Application by Equinor New Energy Limited for an Order granting Development Consent for the Sheringham and Dudgeon Extension Projects

Response to the following responses of to the ExA's WR2;

Submitted on behalf of Mr Clive Hay-Smith, Mr Paul Middleton and Priory Holdings Limited (refs: 20033312, 20032995 and 20033311)

Planning Inspectorate Reference: EN010109

Title:
**Tree Preservation Order
 and Hedgerow Plan**
 Sheet 2 of 40

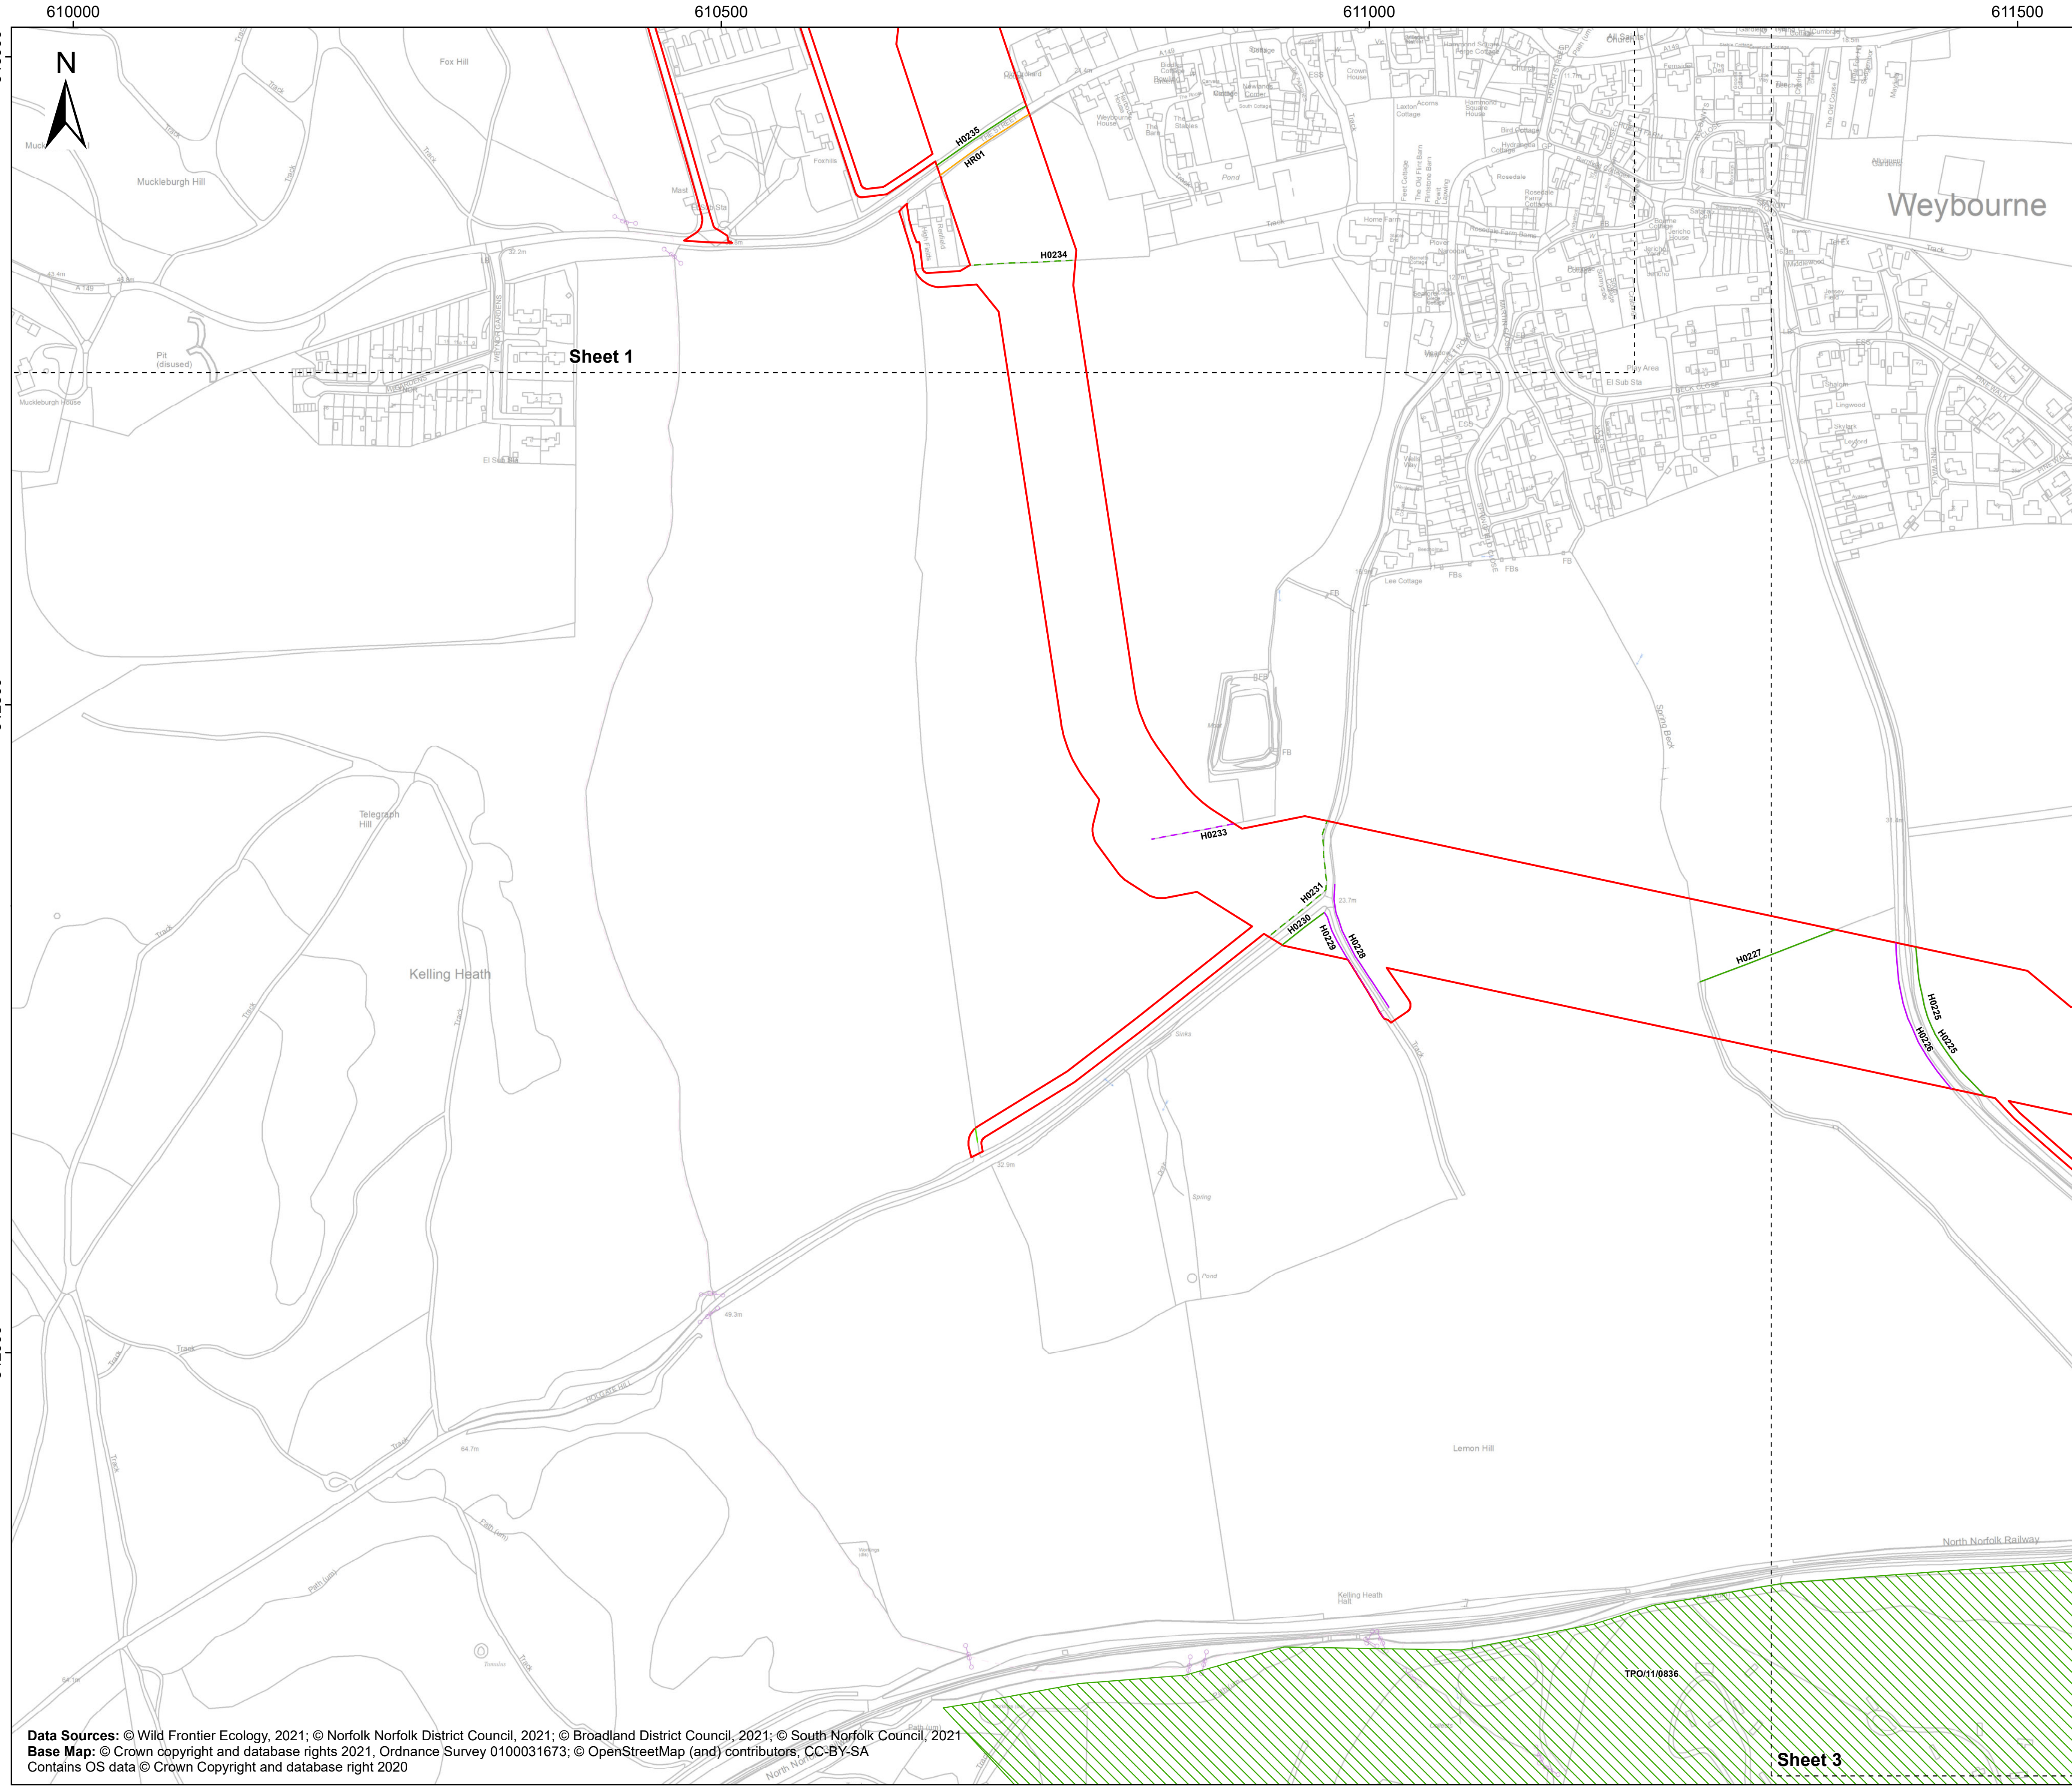
1. Our comments in relation to the ExA's WR2 and relevant responses relate to hedgerows on Mr Clive Hay-Smith's land which are in Order Limits for the purpose of Main Works Access (reference ACC05, BOR plot reference 03-002).
2. ACC05 is shown at Figure 1 below. It leads south from Sheringham Road (A149) outside Weybourne, and connects to Abbey Farm's main farm buildings complex. The importance of the track as a farm access is set out in the IP's Relevant and Written Representations, but in summary it is essential to Mr Hay-Smith and Mr Middleton's farm operations.

3. ACC05 comprises an unsurfaced single farm track. For the first 175 metres as it leads from Sheringham Road, the track is bounded on either side by a mature, mixed species hedgerow (the 'hedgerows'). A photo of part of the hedgerows is shown below at Figure 2. The width of the track between the hedgerows is four metres. The aggregate length of the hedgerows is 350 metres.

8. With reference to BS 5837:2012 this requires adoption of a root protection zone (RPZ) x12 stem diameter, as referenced in the Application Arboricultural Survey Report. Stem diameters are approximately 80mm, corresponding with a RPZ of 0.5 metres either side

of the hedgerow. In practice this gives a maximum working width for ACC05 of three metres.

9. HGV vehicles are up to a maximum 2.9 metres in width, and it is reasonable to assume HGVs of such dimensions will be used for the development (we have been unable to find any reference in the ES). This leaves no room for error for HGV construction traffic straying off a three metre corridor in order to avoid straying into the RPZ with associated damage to the hedgerows' roots. In practice we consider it is inevitable that over the course of the construction programme that HGVs and LVs will stray into the RPZ and that cumulatively that damage will be done to the hedgerows.

13. In the circumstances described above, (specifically with reference to paragraph 8) and given the constrained width of the access track and associated RPZ, we do not consider it reasonably possible that the measures detailed in the Arboricultural Survey Report [APP-228], and the Outline Landscape Management Plan (Revision C) will prevent harm to the hedgerows, nor to realise the Applicant's policy to 'retain and protect' the hedgerows in this location.

14. The risk of harm is nevertheless avoidable; Mr Hay-Smith has proposed to the Applicant they adopt an alternative access route, to the immediate east of west or ACC05 for the first 175 metres leading from Sheringham Road, but with sufficient separation from the hedgerow to prevent harm. There would be no operational disadvantage to adopting such a variation.
